From: Tristen Lamb
Sent: Thursday, October 04, 2018 10:44 AM
To: Chelsea Benner
Cc: Holly Erdman
Subject: RE: Notice of Application

For project SD-18-00002, all Environmental Public Health comments have been outlined in Ordinance No. 2006-60 for the Vantage Bay Rezone (Z-06-25) and Preliminary Plat (P-06-26).

Subject: Notice of Application

Please see the attached notice of application for the shoreline substantial development permit SD-18-00002. Please submit all comments prior to 5pm on Monday, October 15, 2018.

JOB NO.: 1396/001/014
 DWG. NAME: ST-01
 DESIGNED BY:
 DRAWN BY: CJR
 CHECKED BY:
 DATE: 12/12/2018
 DATE OF PRINT:
ST-01
 1 OF 4 SHEETS

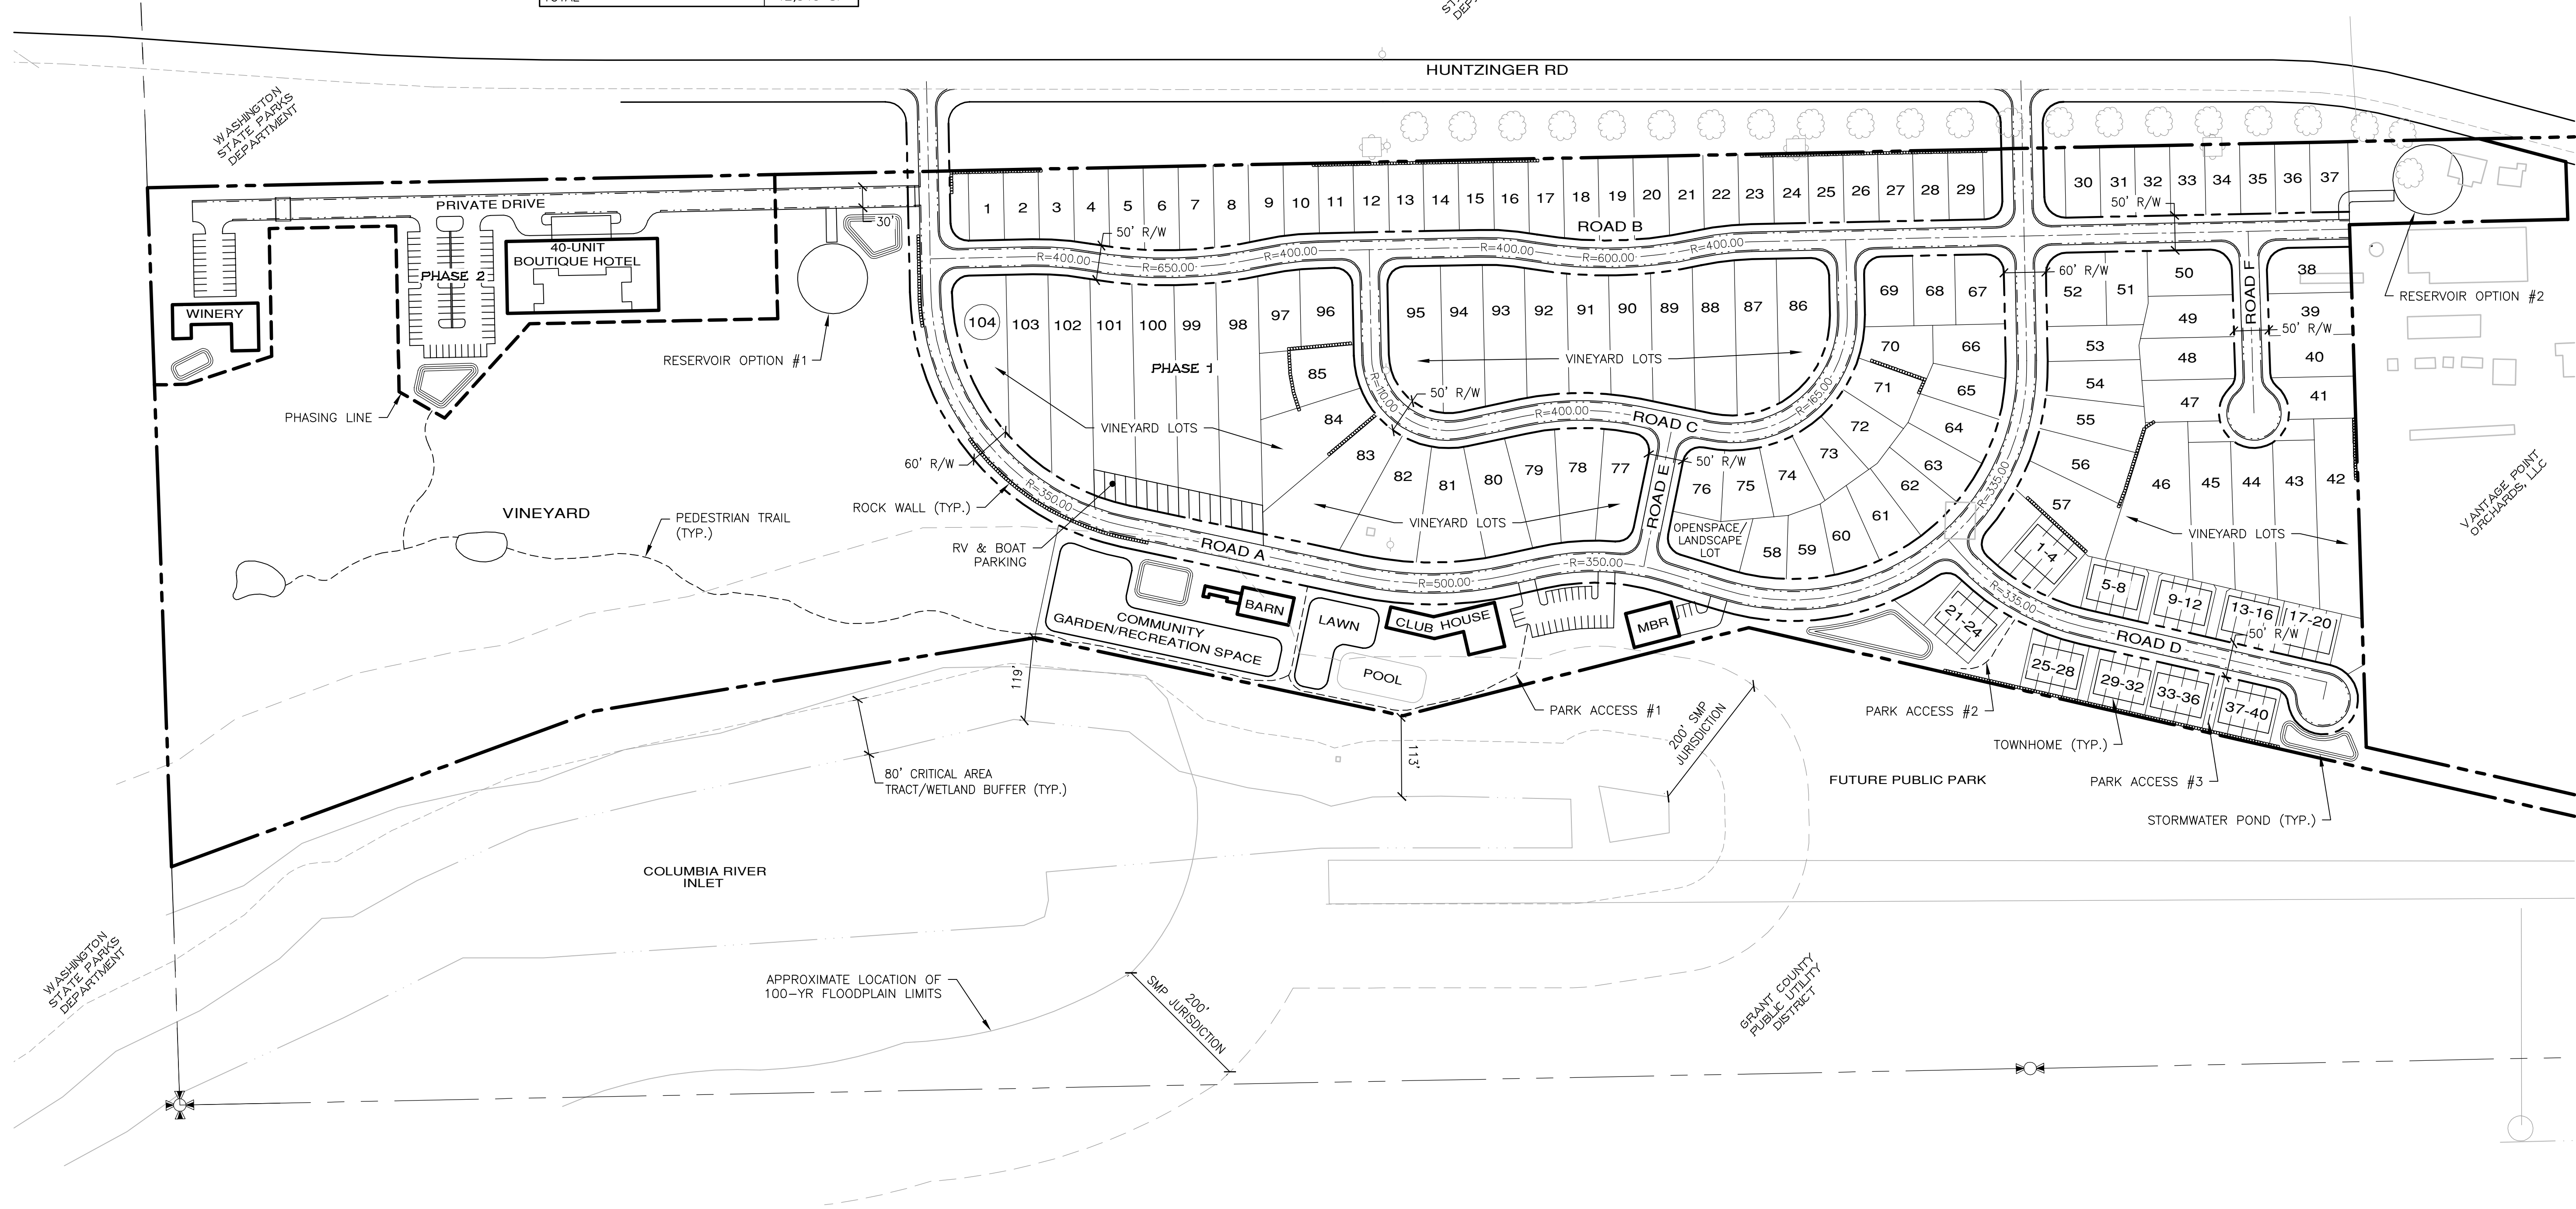
B. Per the Kittitas County Shoreline Master Plan, there shall be a minimum setback of 100 feet from the Ordinary High Water Mark for all on-site sewage treatment systems.
